KIRKLEES METROPOLITAN COUNCIL INVESTMENT & REGENERATION SERVICE

DELEGATED DECISION TO DETERMINE APPLICATIONS FOR LISTED BUILDING CONSENT

Reference No:	2025/65/92452/W
Site Address:	Foot Asylum, 33-37, King Street, Huddersfield, HD1 2PZ
Description:	Listed Building Consent for external alterations and erection of illuminated signs (within a Conservation Area)
Recommending Officer:	Nicole Helliwell

Officer Report

Drawing: PROPOSED ROLLER SHUTTER DETAIL
Scale: As indicated @A1
Date: 31.03.2025
Author: FQ
Checked: MS

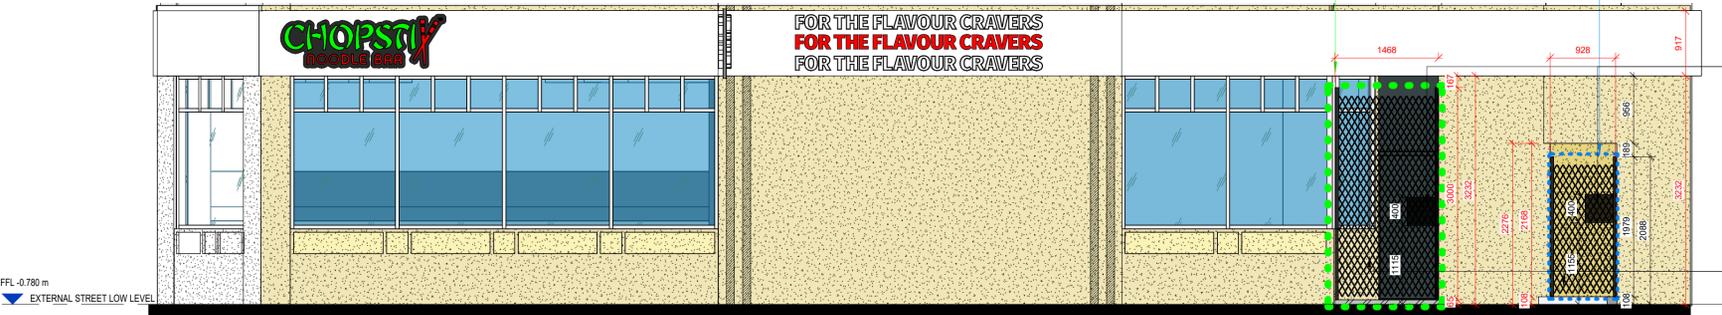
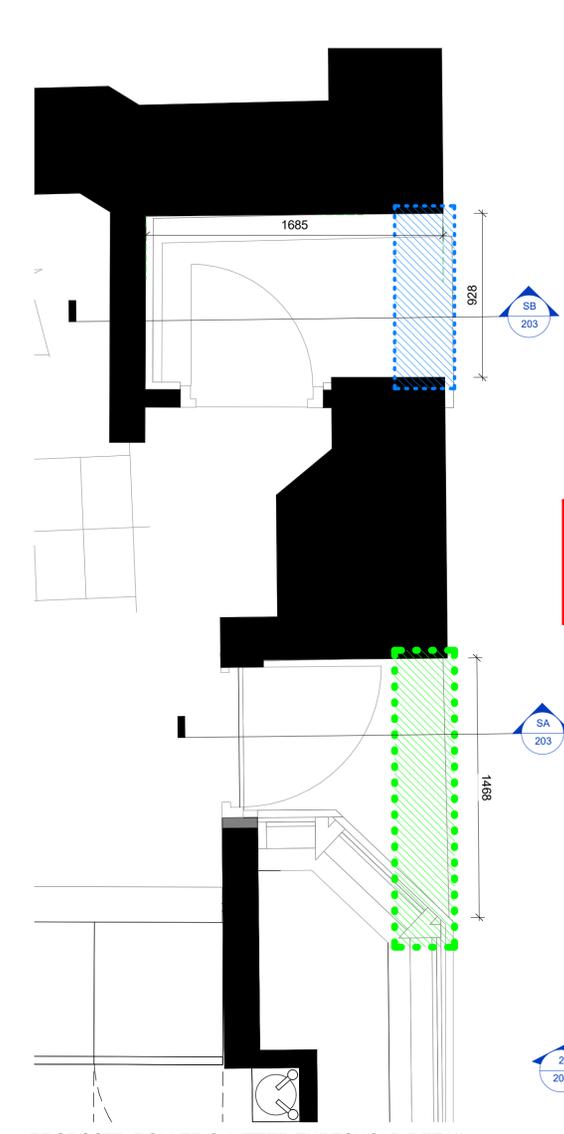
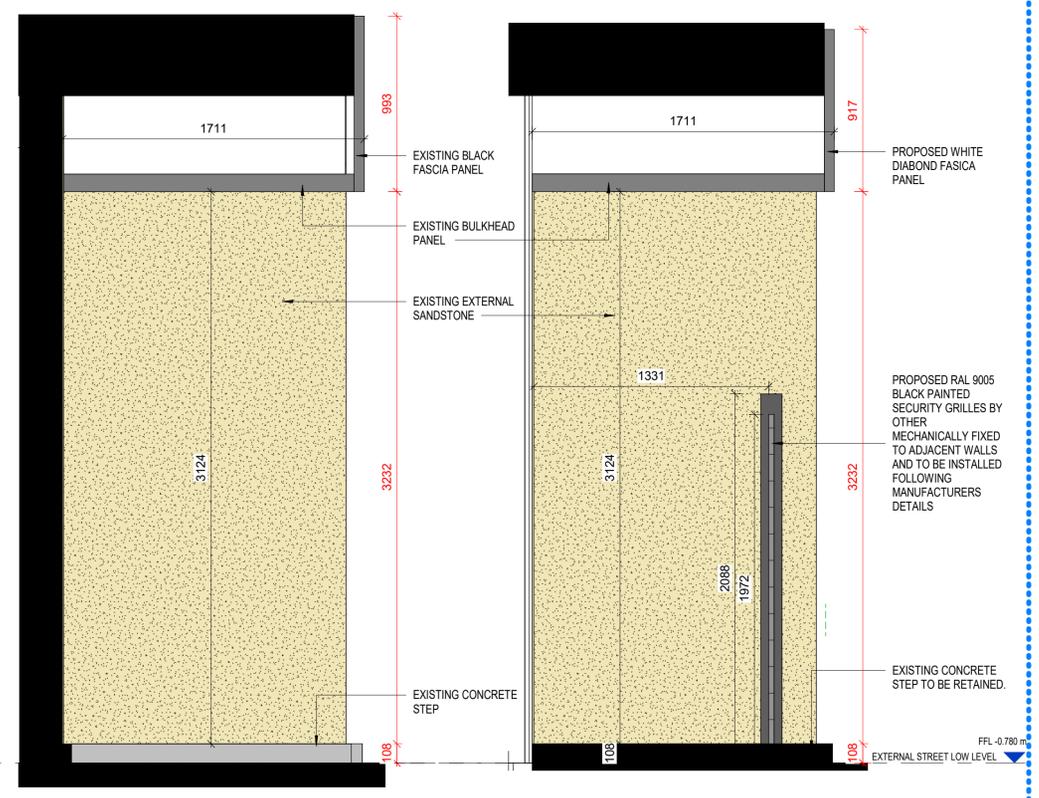
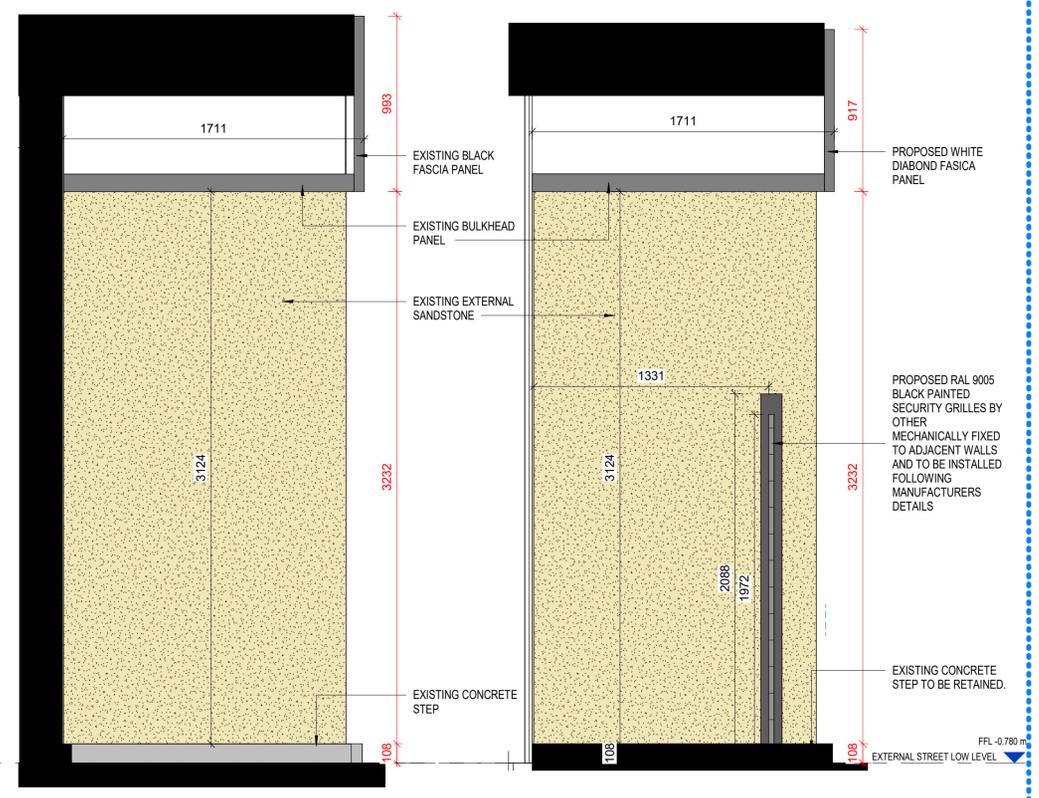
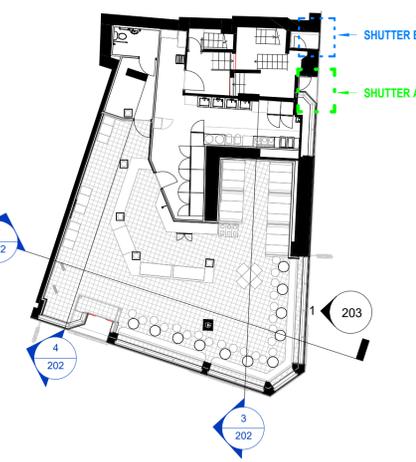
Amendments were sought during the course of the application. A request was made to alter the roller shutters to metal gates to reduce the visual impact on the shop front. Revised plans were submitted showing recessed black security grilles which were considered acceptable and more sympathetic with regard to visual amenity. Whilst a request was also made for the agent to update the proposed elevational plan to accord with this, no amended plan was forthcoming.

[KC Conservation & Design](#) – Concerns regarding the visual impact of the roller shutters on the shop front. Amended plans were requested and received on this basis.

The application site is located within the Huddersfield Town Centre Conservation Area and is Grade II listed. As such, KC Conservation and Design were informally consulted on the proposed scheme. Whilst officers raised no concerns regarding the illuminated signage and cooking ventilation/extract, concerns were raised in relation to the roller shutters proposed within the recessed areas of Elevation A. A request was made to alter the roller shutters to metal gates to reduce the visual harm to the shop front. Revised plans were submitted showing recessed black security grilles which were considered acceptable and more sympathetic with regard to visual amenity. Given the alterations made, it is considered that the proposal would not result in any detrimental harm to the significance of the setting of the Conservation Area and the listed buildings and would be visually acceptable with regard to their materials, siting and design.

- Security grilles are proposed within the recessed areas within Elevation A of the building
- The shutters would be black painted (RAL 9005) and would be mechanically fixed to the existing walls
- Shutter A would measure approx. 1.47m wide and would have an overall height of approx. 3m.
- Shutter B would measure approx. 0.93m wide and would have an overall height of approx. 2m.
